Tween Bridge Solar Farm

9.10 Statement of Common Ground with National Highways

Deadline 1 May 2026

Document Reference: 9.10

Document Ref: 6.4.6.4 AFPP Reg: 5(2)(a) Revision: 2
 PINS Number: EN010148 Drawing Status: Final
 Drawn: LAB Checked: HS Approved: KC Date: 17/04/2026

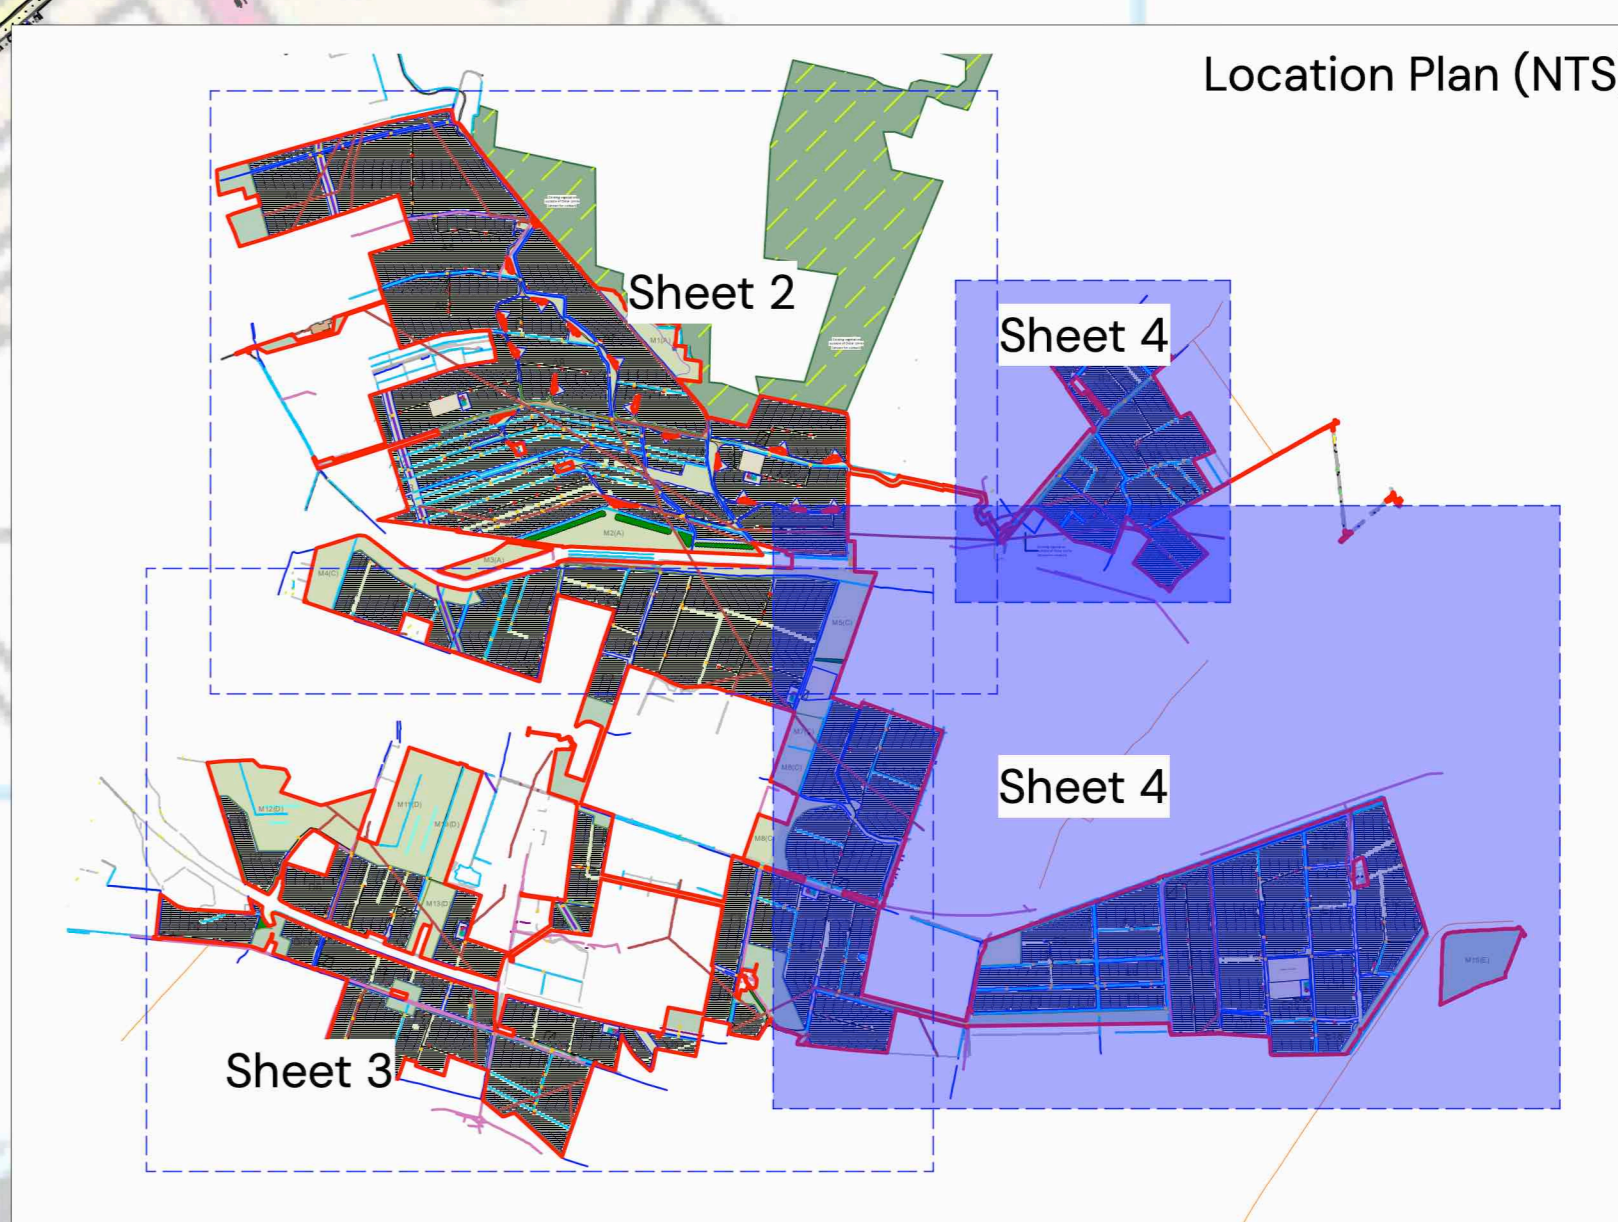
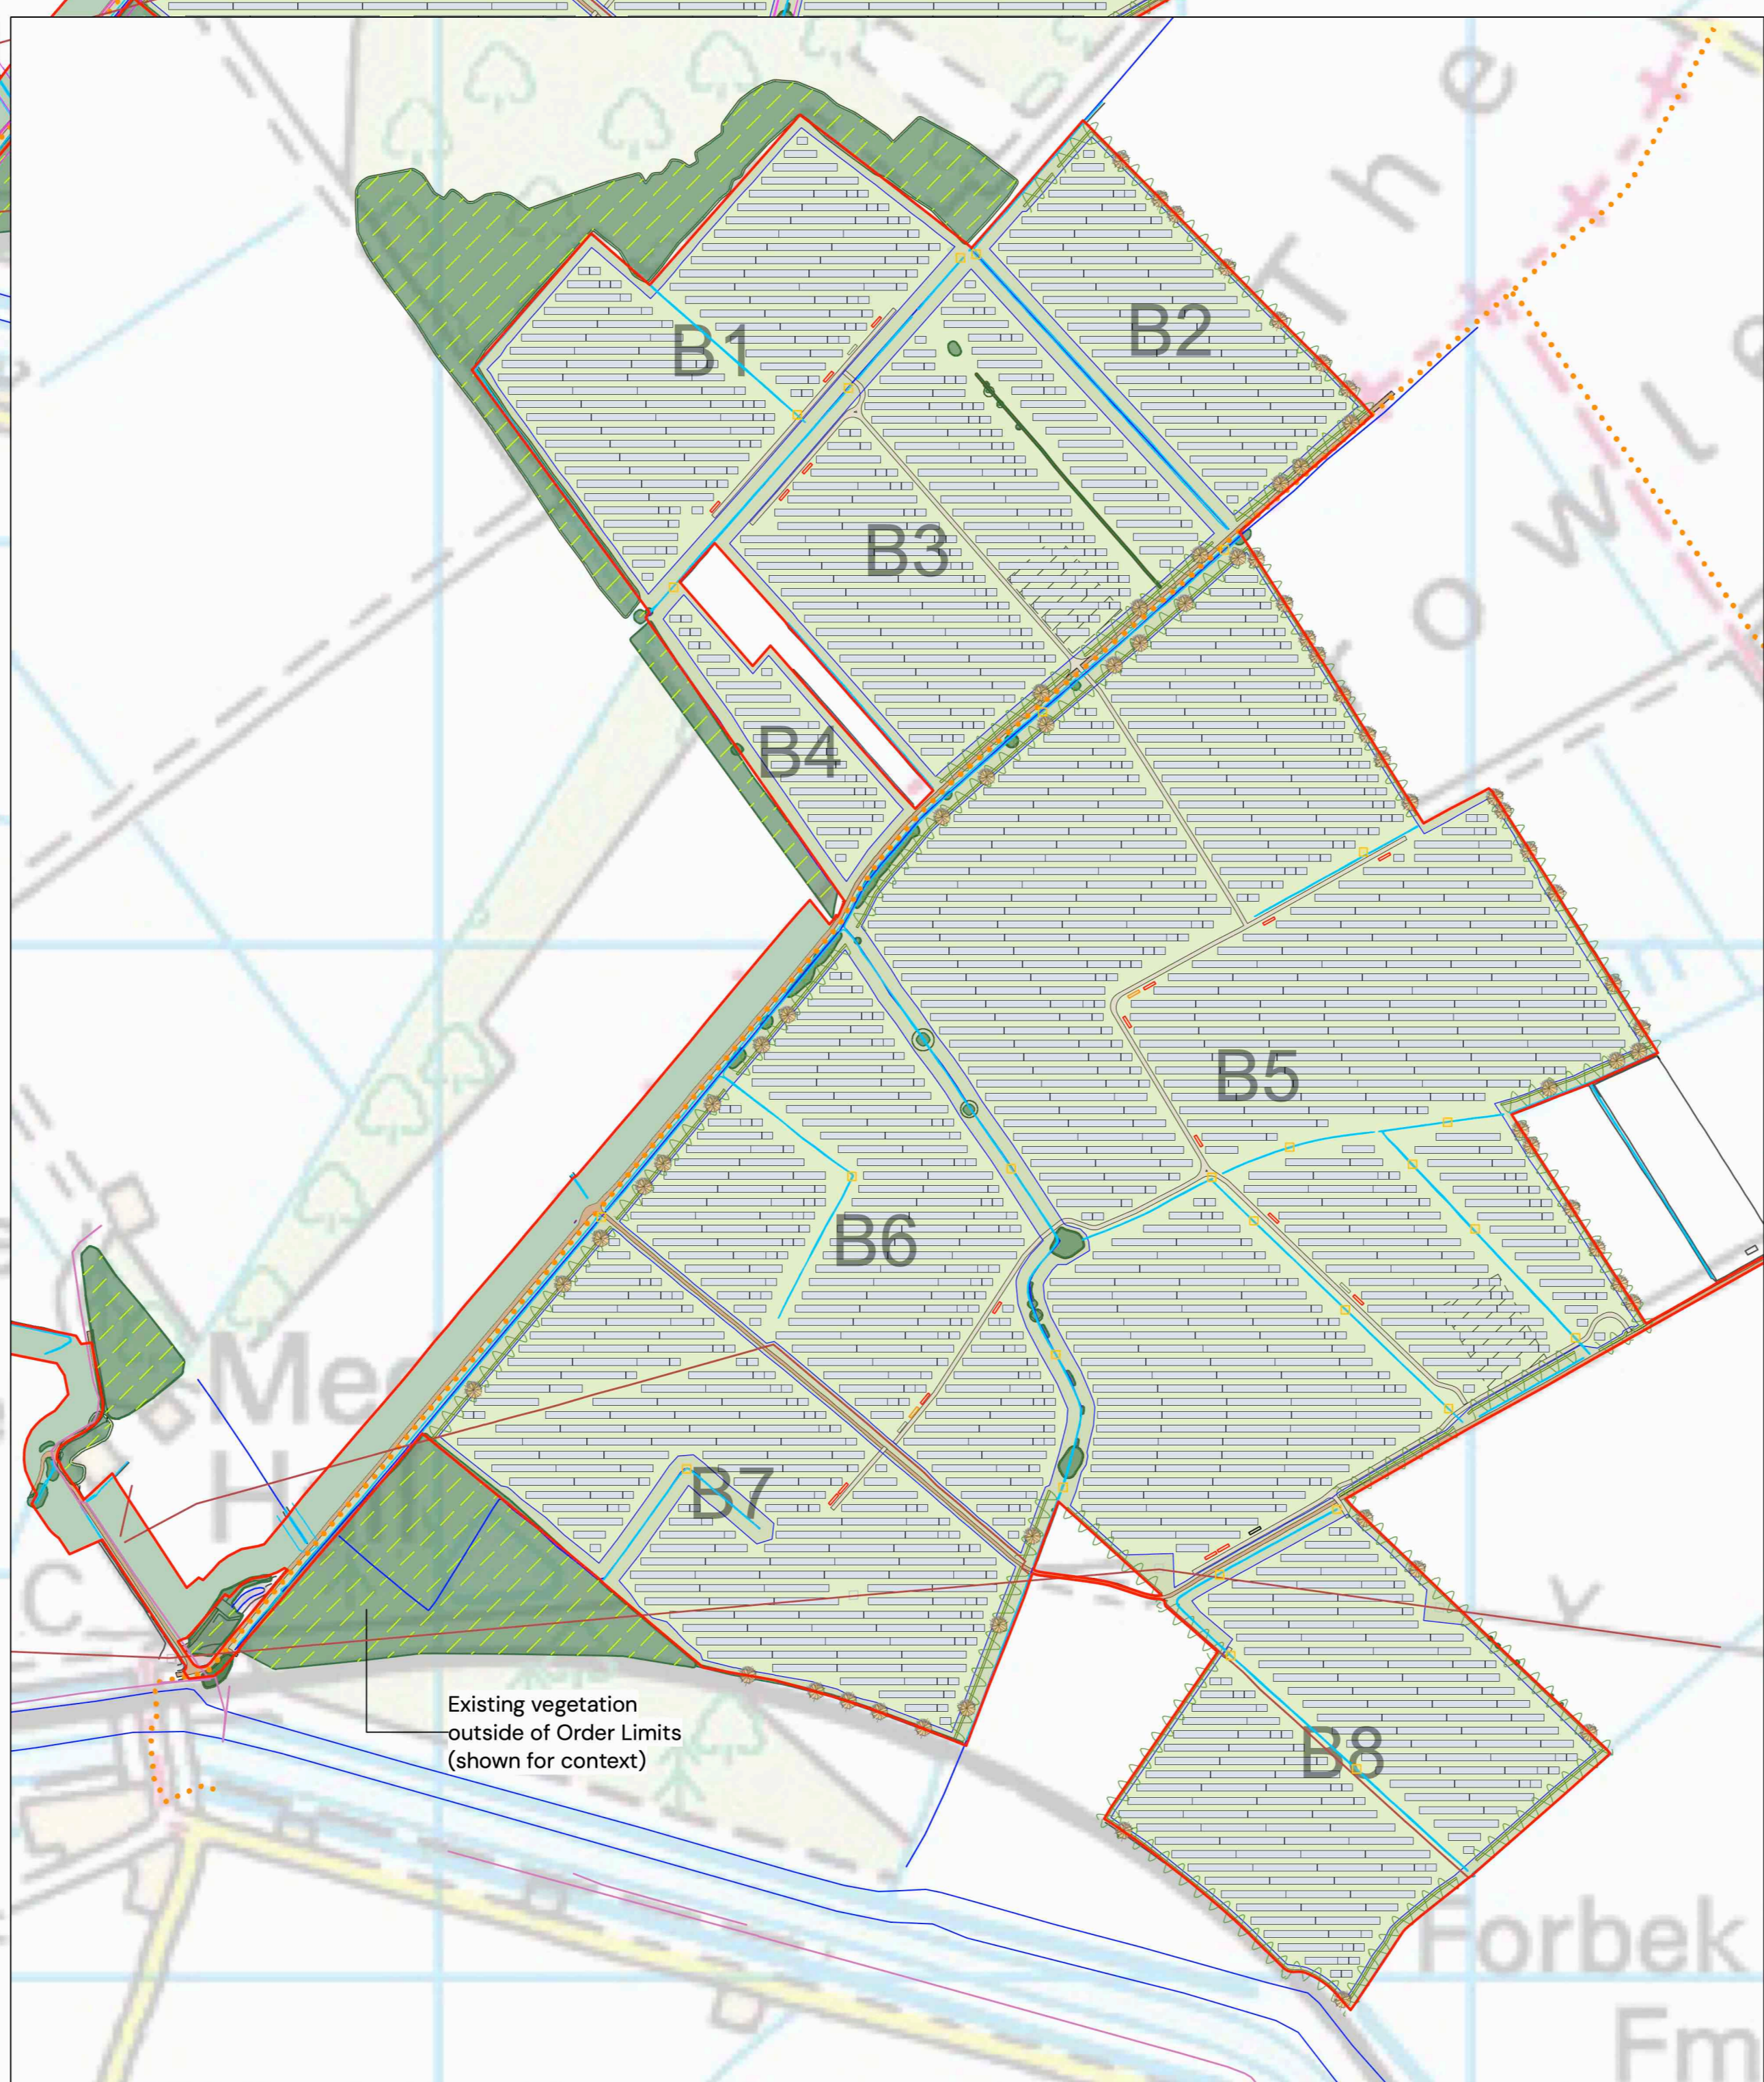
<p>screening) and also does not appear to make any provision for failed planting to be replaced. NH invites the Applicant to provide details of the location of planting proposed to mitigate glint and glare effects.</p>	<p>nonetheless been proposed as part of the Scheme to reduce the effect further over time.</p> <p>The Applicant agrees that appropriate provision must be made for the ongoing management and maintenance of planting. The proposed management prescriptions for retained and proposed planting are set out in Table 4-1 of the Outline Landscape Ecological Management Plan [Document Reference 7.6 Revision 2] submitted at Deadline 1.</p> <p>The location of the proposed mitigation planting to screen views of the fencing and panels and in turn to mitigate glint and glare effects are set out on the drawings at ES Figure 6.4 Landscape and Visual Mitigation Strategy [Document Reference 6.4.6.4 Revision 2] submitted at Deadline 1.</p>
